From: Anita Gardner
Sent: 31 July 2019 09:23
To: Planning.Responses
Subject: FW: EP/64/19/DOC
Attachments: 4501_Marmont_EastPreston_DrainageLayout_F_REV C.pdf; 4501_Marmont_EastPreston_DrainageNetworkCalculations_F_REV B.pdf

From: Laura Gibbons [REDACTED]
Sent: 25 July 2019 12:14
To: Ben Daines [REDACTED]
Subject: RE: EP/64/19/DOC

From: Laura Gibbons [REDACTED]
Sent: 22 July 2019 11:52 [REDACTED]
To: Ben Daines [REDACTED]
Subject: RE: EP/64/19/DOC

Drawing No: X:\PROJECTS\4501_Marmont_EastPreston\Plans\4501_Marmont_EastPreston_DrainageLayout.dwg

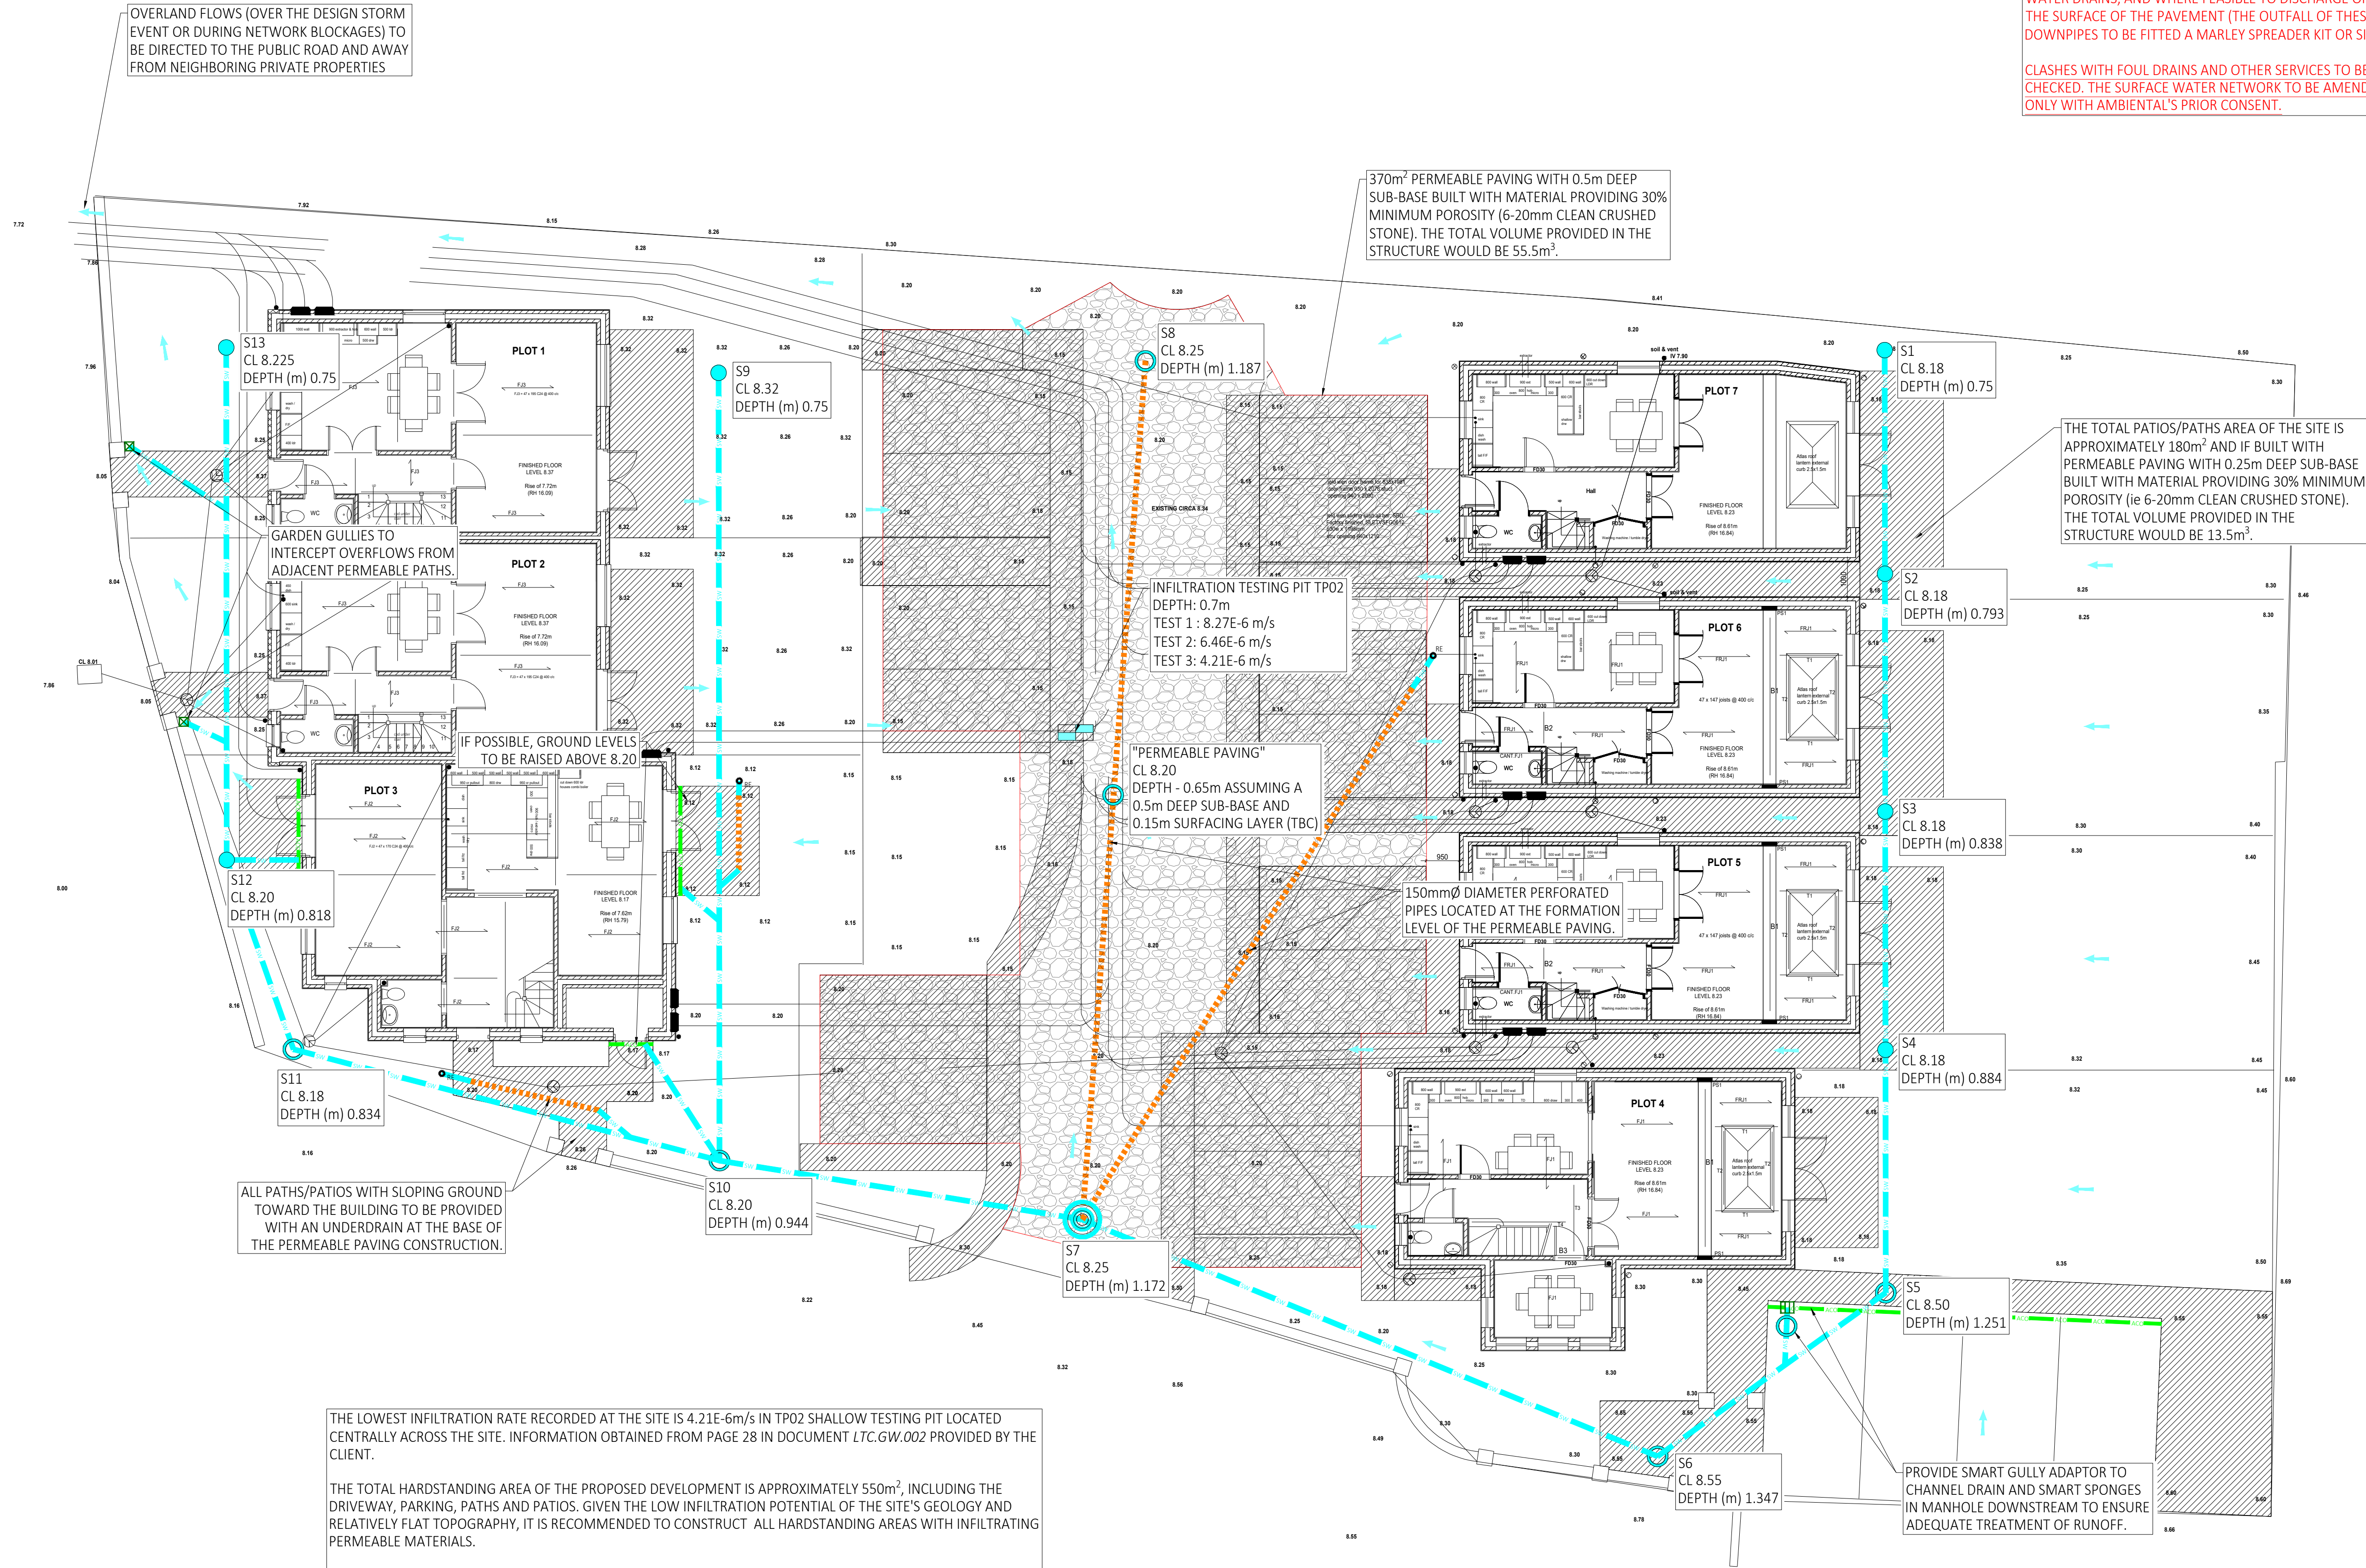
Switching diffuser units for perforated pipe isn't sufficient. Infiltration should not occur within 5m of a building when the infiltrating structure is dealing with more water than that which is falling directly on it.

1. Please provide further details of the shallow swale, i.e. bed level and bank levels.
2. Diffuser units are located closer than 5m to buildings.
3. Please provide updated construction detail drawings.

Please find attached amended information which hopefully addresses the concerns set out in your email of 25 July.

Please find attached additional drainage details which hopefully address the comments set out in your email below.

INDICATIVE PERMEABLE PAVING AND GEOCELLULAR SYSTEM DETAIL
(SCALE 1:20 - NOT FOR CONSTRUCTION)

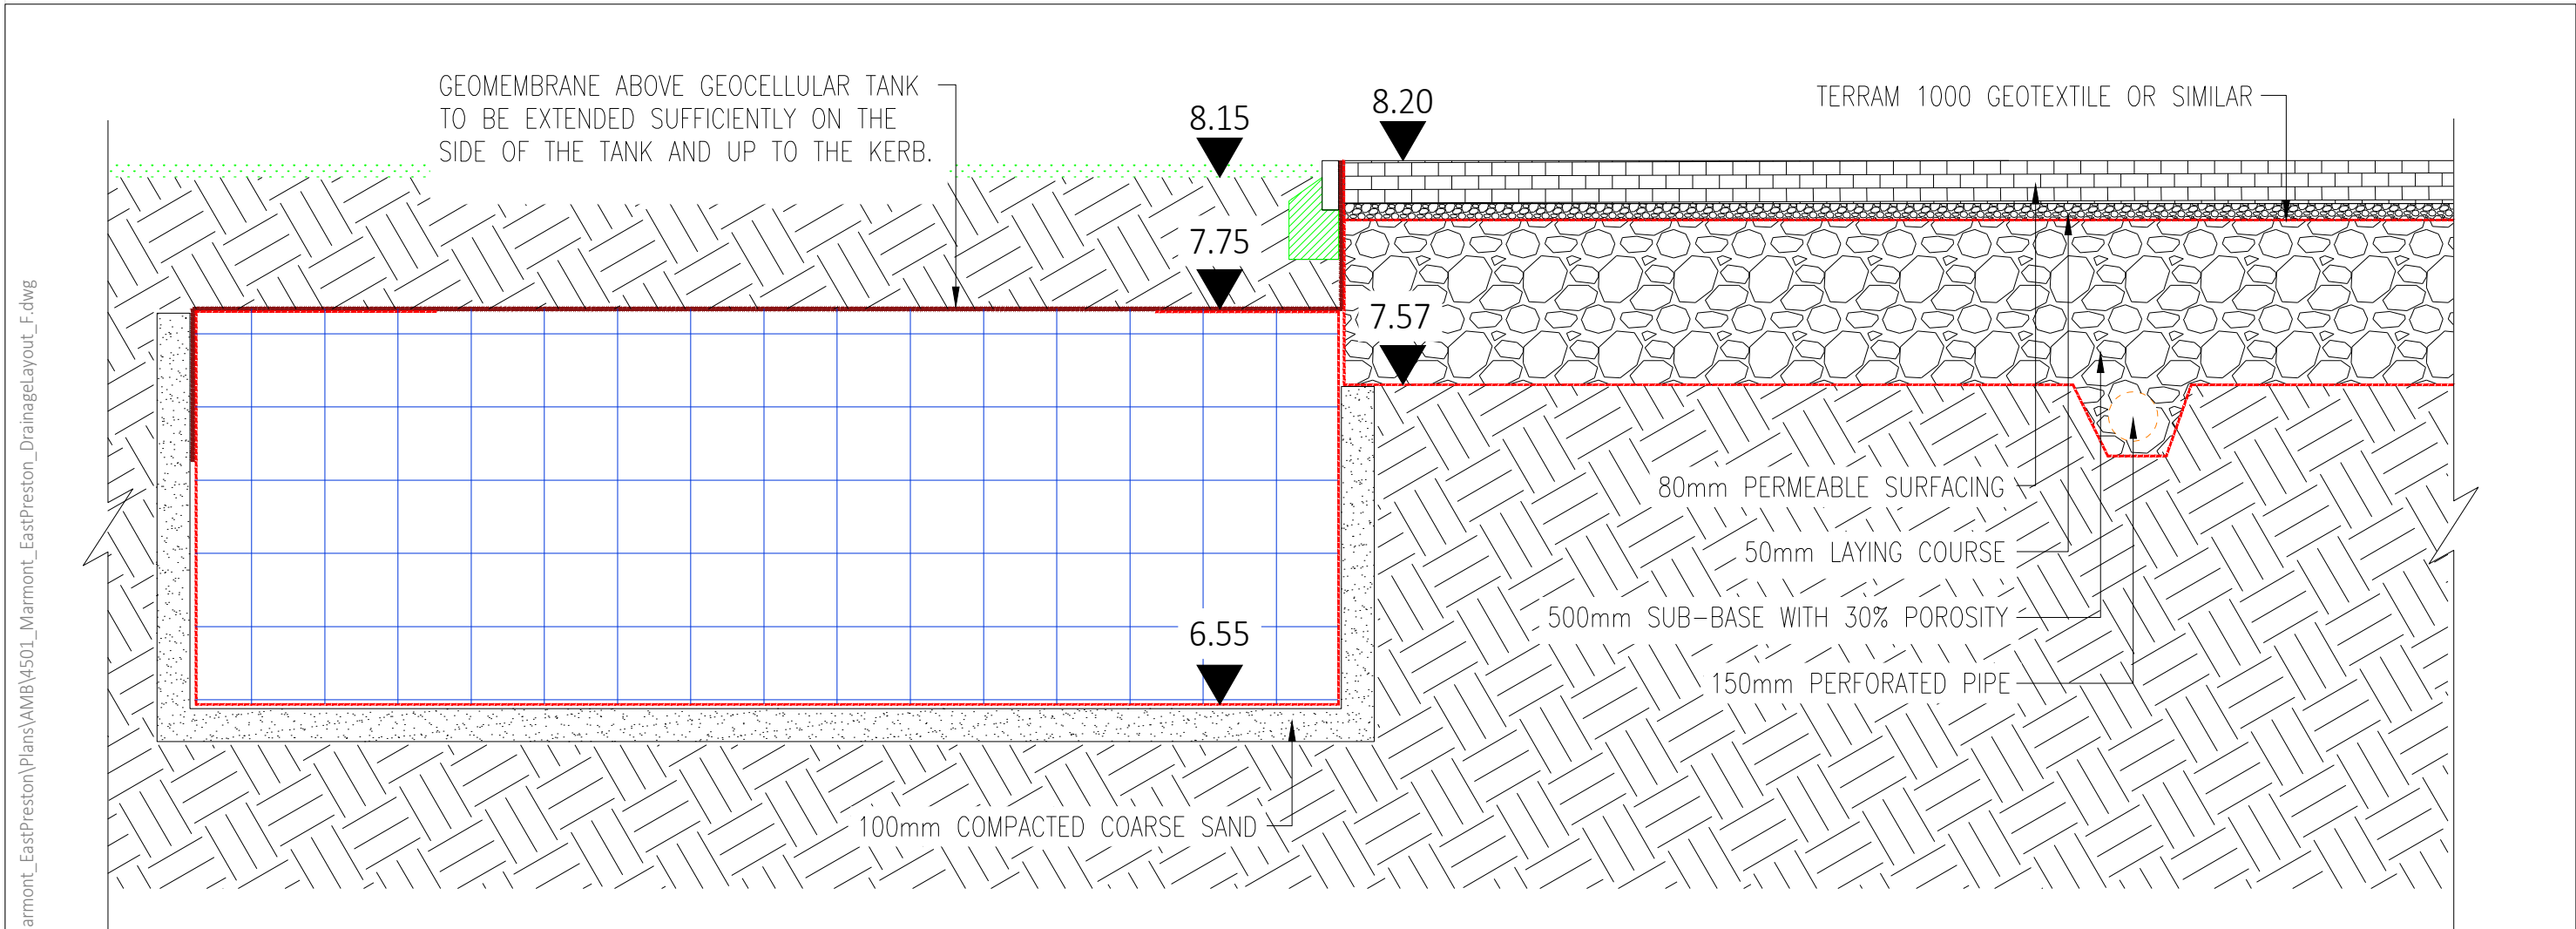
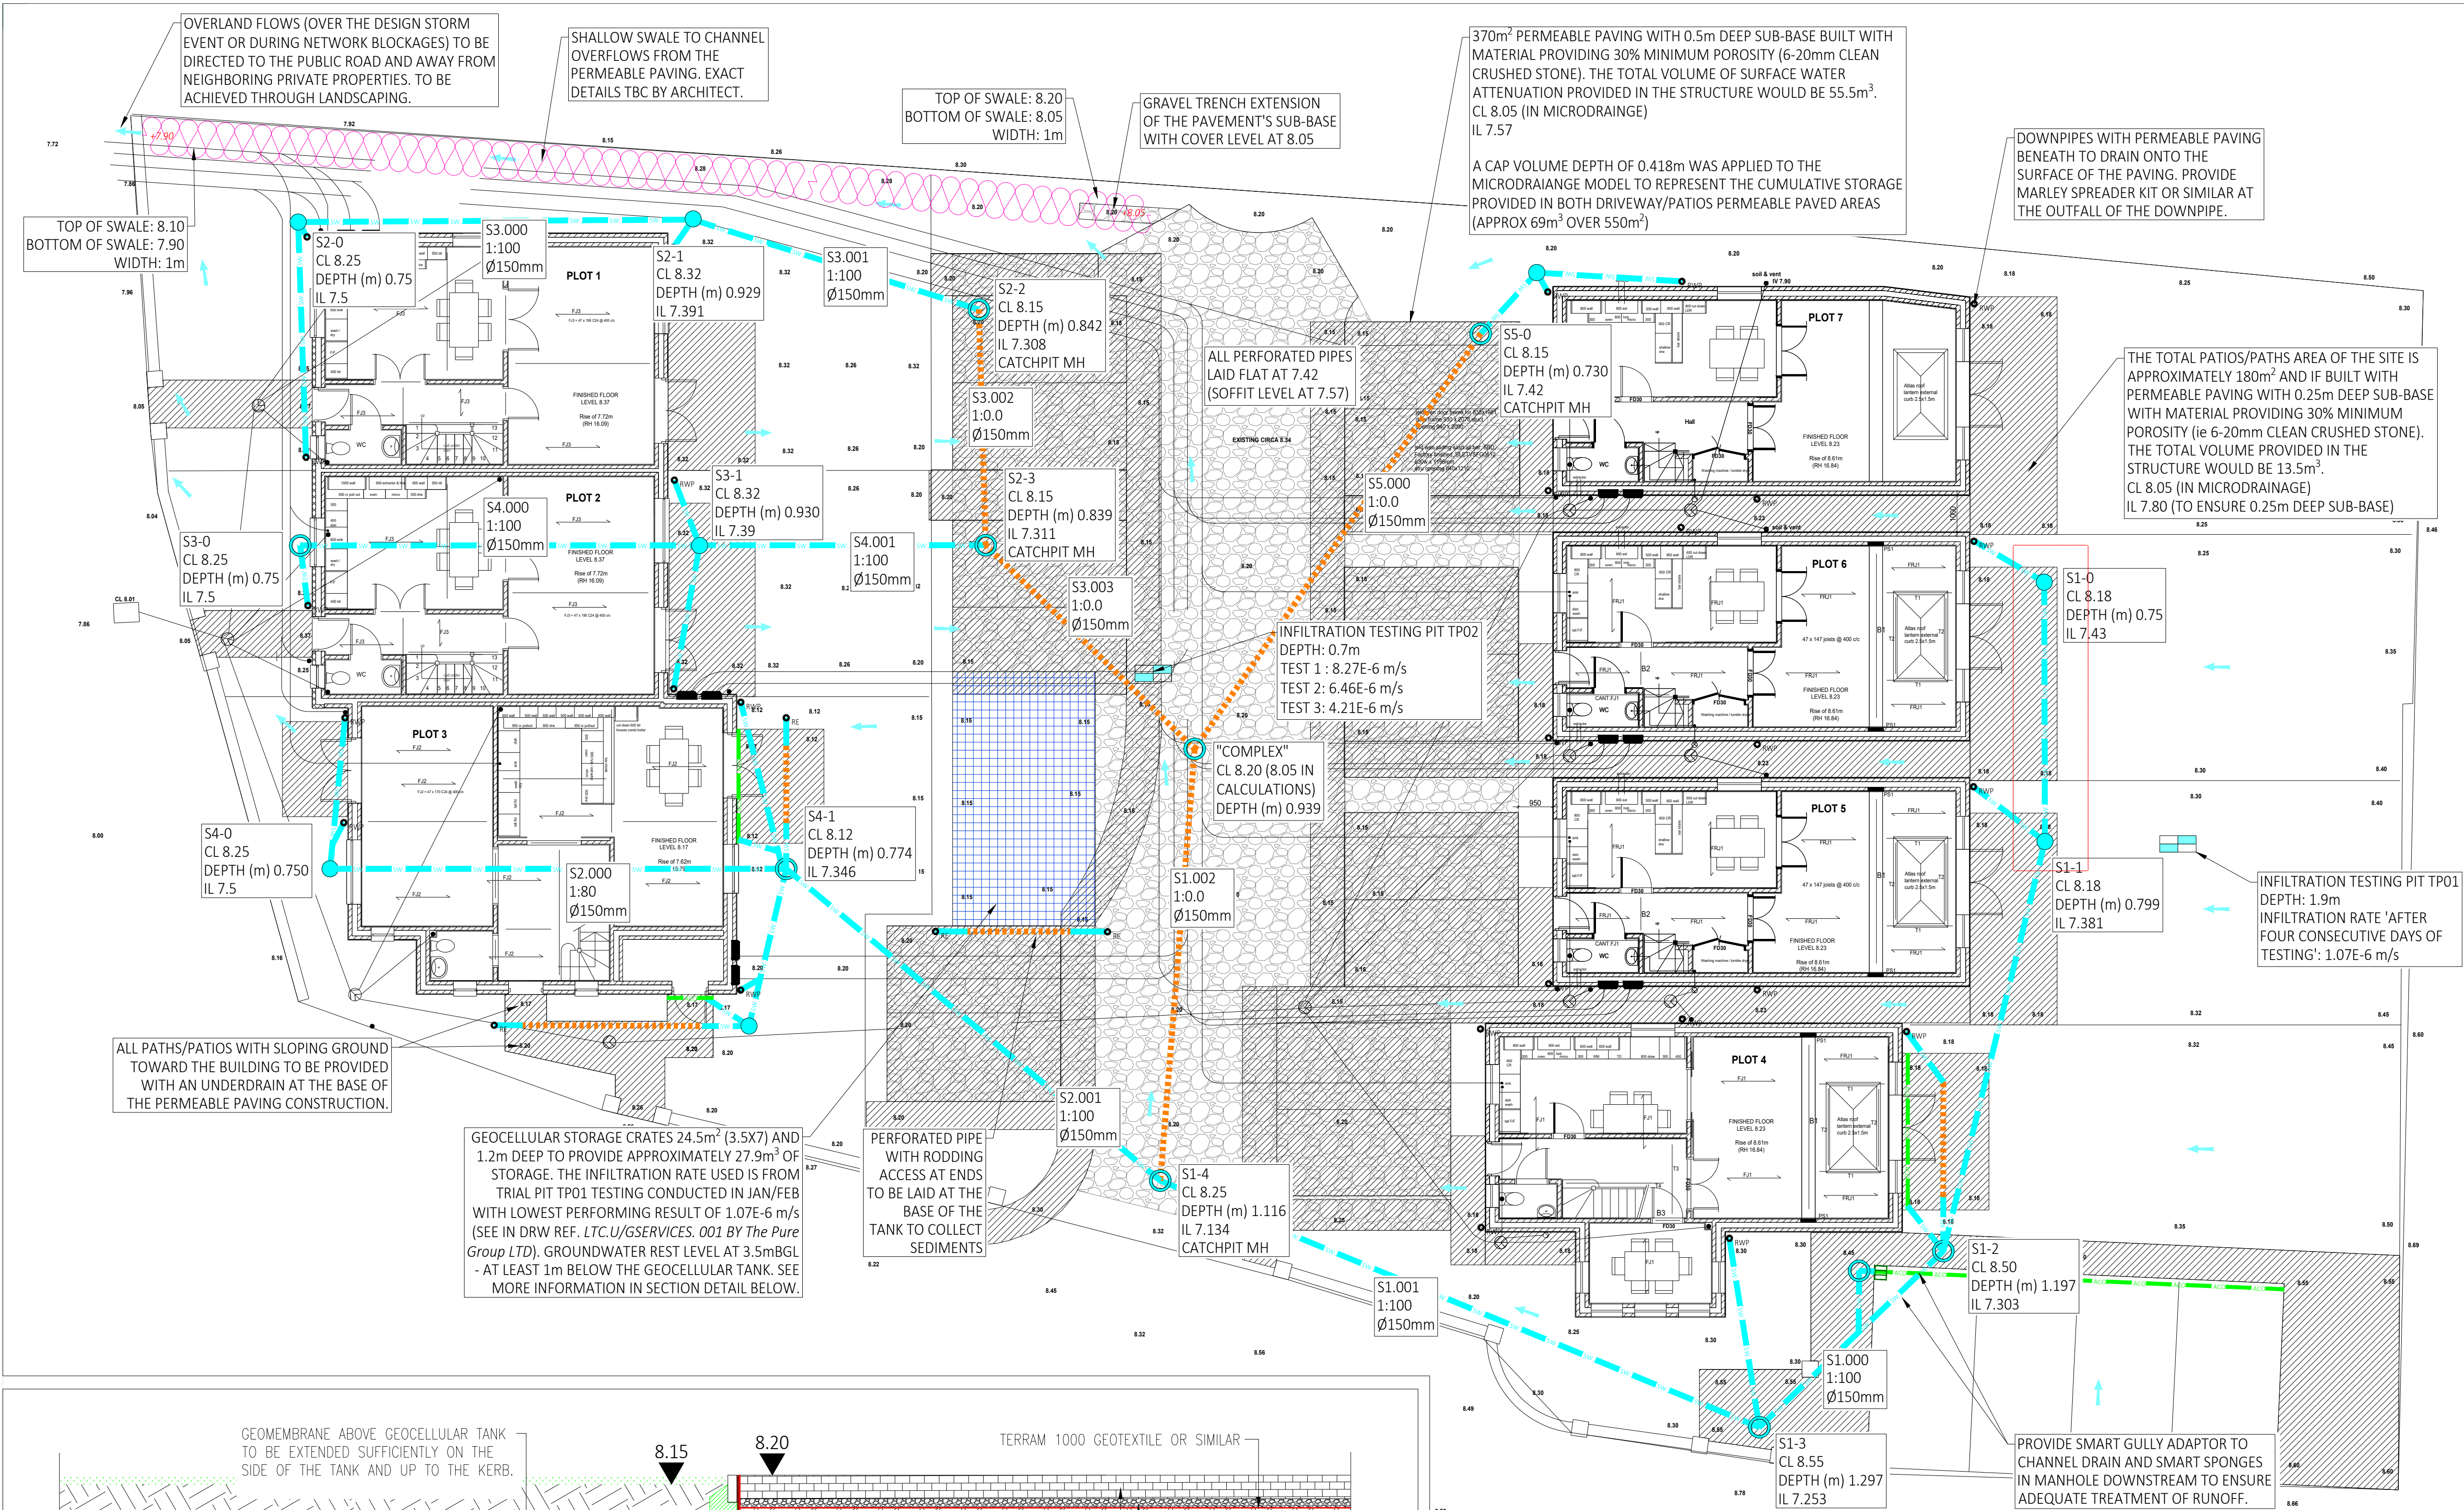
1. Layouts need to clearly identify the formation and finish level proposed for permeable paving. On drawing & section detail
2. Please can invert levels and not depths be expressed at each manhole. Added

3. The size and fall of all pipes needs to be clearly labelled on the plan. Added
4. Catchpit locations need to be clearly marked on the plan. Added
5. The factor of safety used in calculations needs to be revised to be compliant with requirements set out within CIRIA. Please refer to our checklist for further information on this. Used CV=1 and FoS = 3, this increased storage with approx. 30%. Added a geocellular tank to the side of the pavement in the soft landscaping to make up for it, see section detail on drawing.
